Norfolk Boreas Offshore Wind Farm Applicant's Comments on Deadline 7 Submissions

Applicant: Norfolk Boreas Limited
Document Reference: ExA.ASR.D8.V1
Deadline 8

Date: April 2020
Revision: Version 1
Author: Royal HaskoningDHV

Relationship of Pre-commencement Plans secured by the DCO and DML's

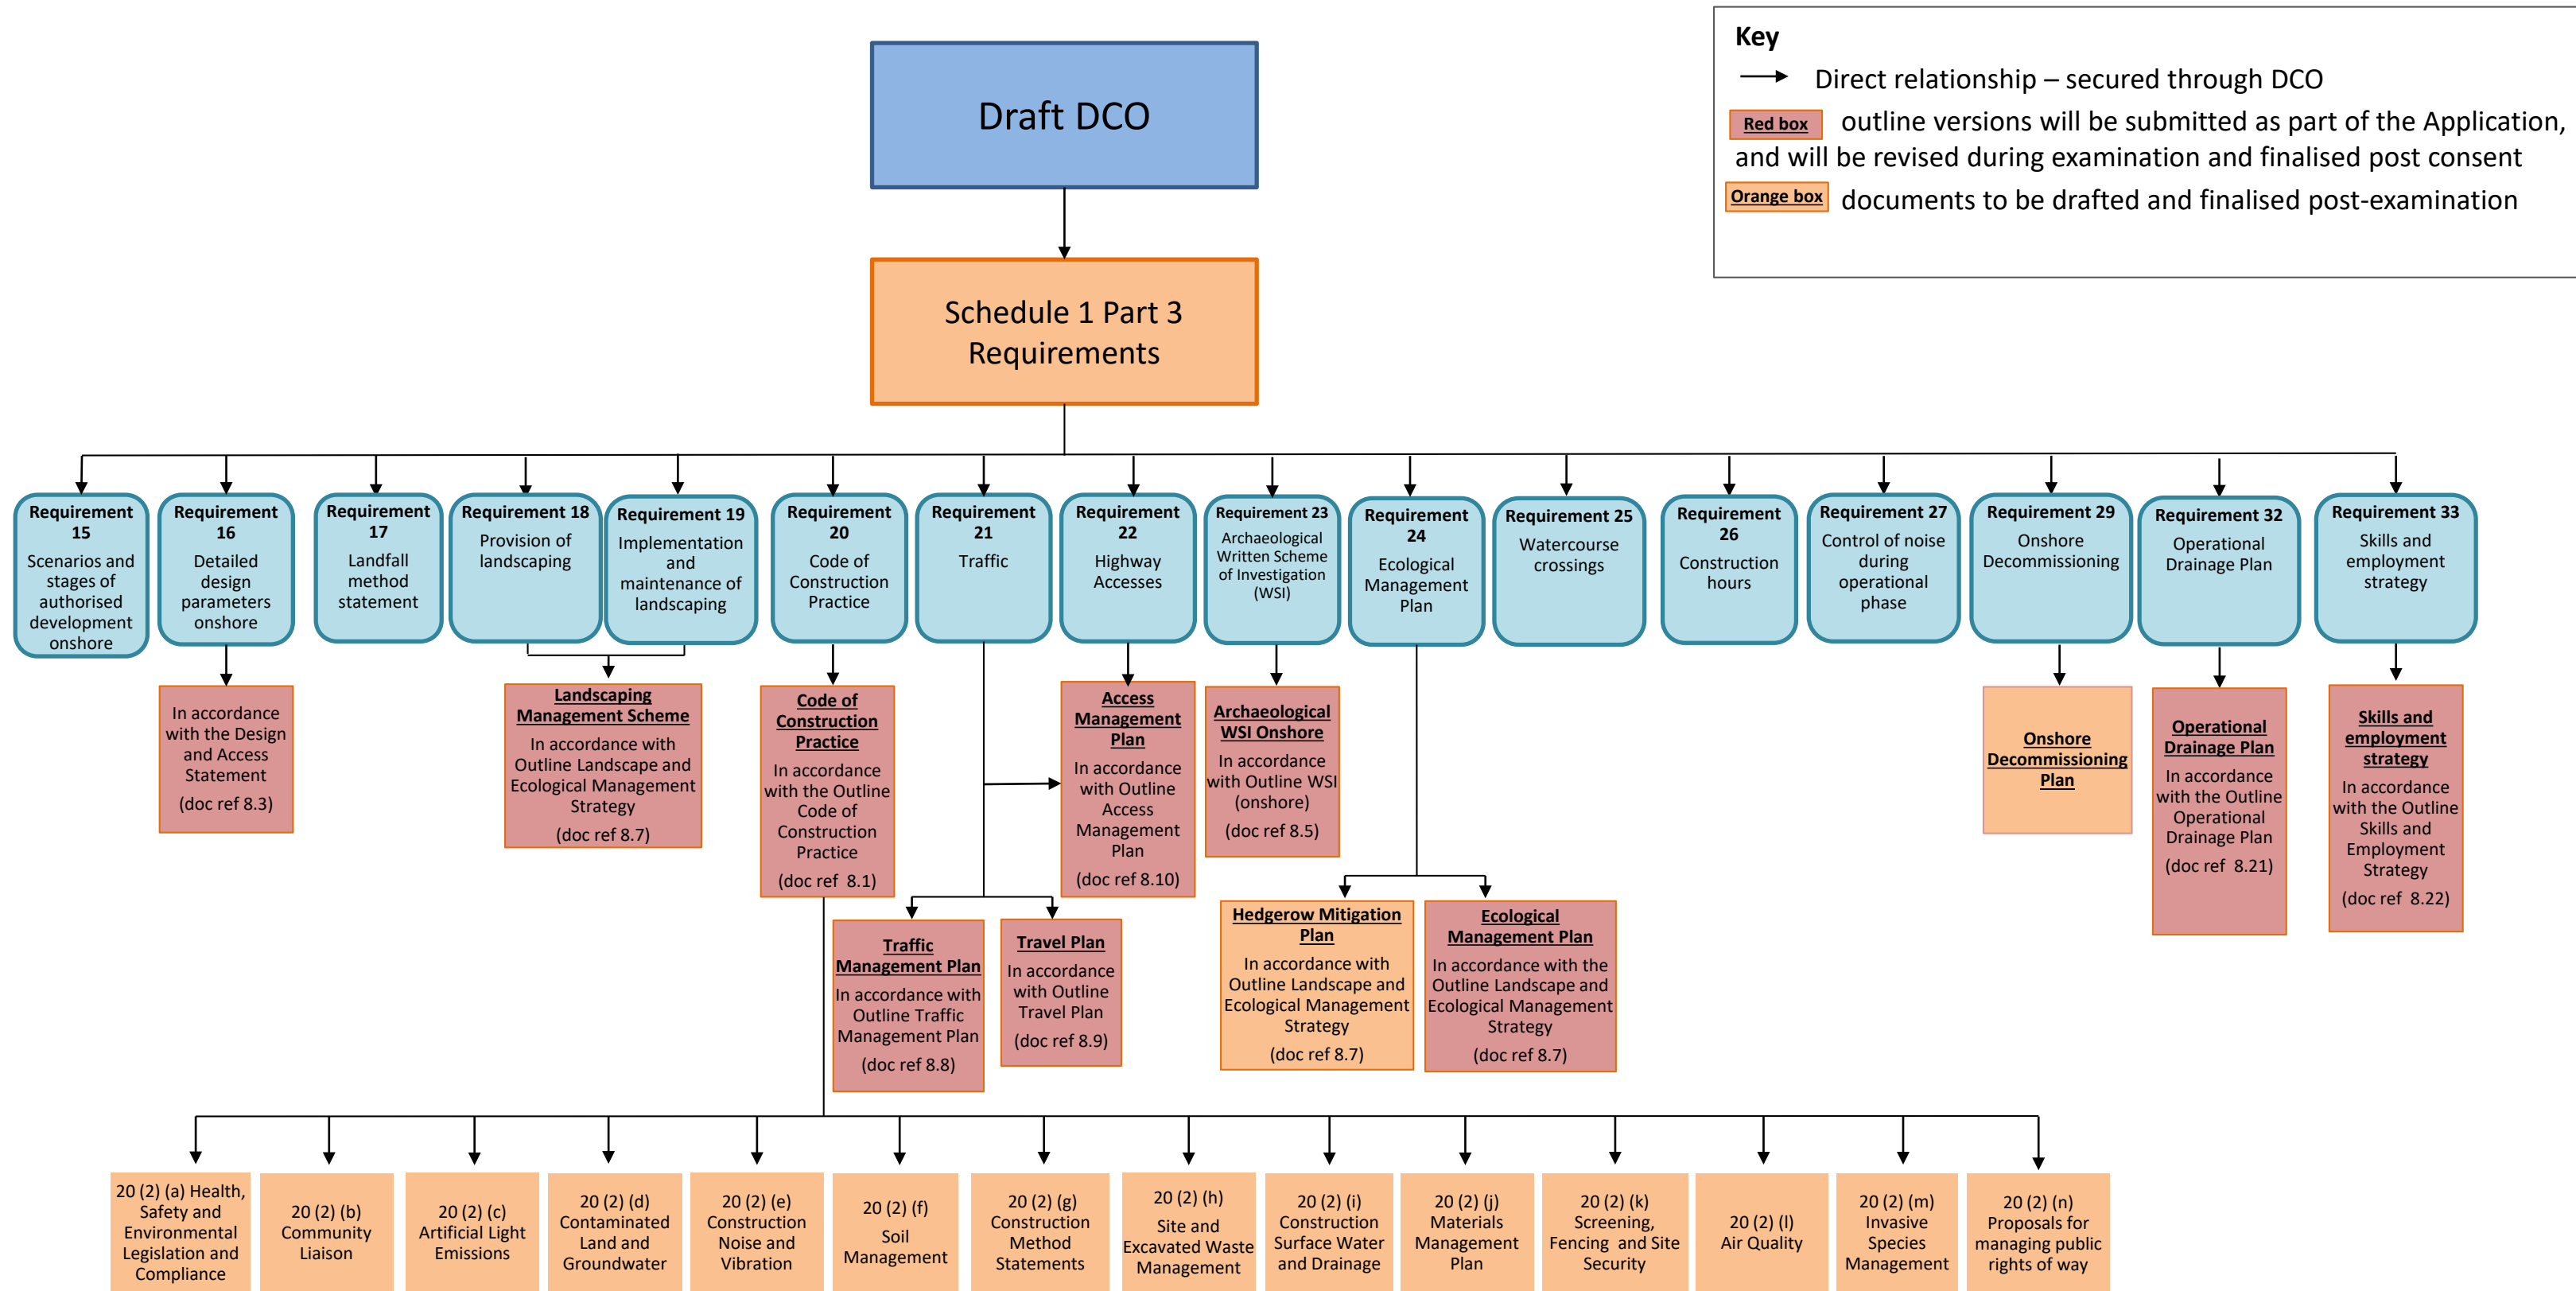
Summary of Submission	Applicant's Comments
<p>Comment is captured within schedule of changes to draft DCO comment above.</p>	
<p>Note on Requirements Annex 1 Diagram 2. On the diagram showing Relationship of Pre-commencement Plans secured by DCO and DMLs, for the offshore section. Natural England considers that reference should be made here to the requirements to submit monitoring methodologies, including the new proposed plan for ornithological monitoring aims and objectives to be submitted</p>	<p>The Applicant will review the Note on Requirements and if considered necessary Annex 1 diagram 2 will be updated to include the 2 strands of the Ornithological monitoring plan. An Updated version of the Note on Requirements will be submitted at Deadline 9.</p>
<p>Schedule of mitigation. In relation to the operations and maintenance section of the table we wish to reiterate the comments we made on the updated CRM for Boreas alone regarding:</p> <ul style="list-style-type: none"> the suggested revision to the draft DCO wording that the Applicant suggested in that document to secure the mitigation and draught height (assuming this was included and still stands) and the need for clarification on points of reference used for hub heights, tidal offset and draught height (i.e. MHWS rather than HAT). 	<p>In response to WQ3.2.1.3 (REP7-017) the Applicant submitted further clarification on the DCO conditions which ensure the collision risk mitigation is secured, and this wording is already included in the schedule of mitigation (Version 3).</p> <p>The Applicant submitted clarification on sea level points of reference as used in the collision risk modelling at Deadline 7 (REP7-031).</p> <p>The Applicant does intend to submit an updated version of the Schedule of Mitigation at Deadline 9 however the Applicant does not consider any updates are required as a direct response to these comments.</p>
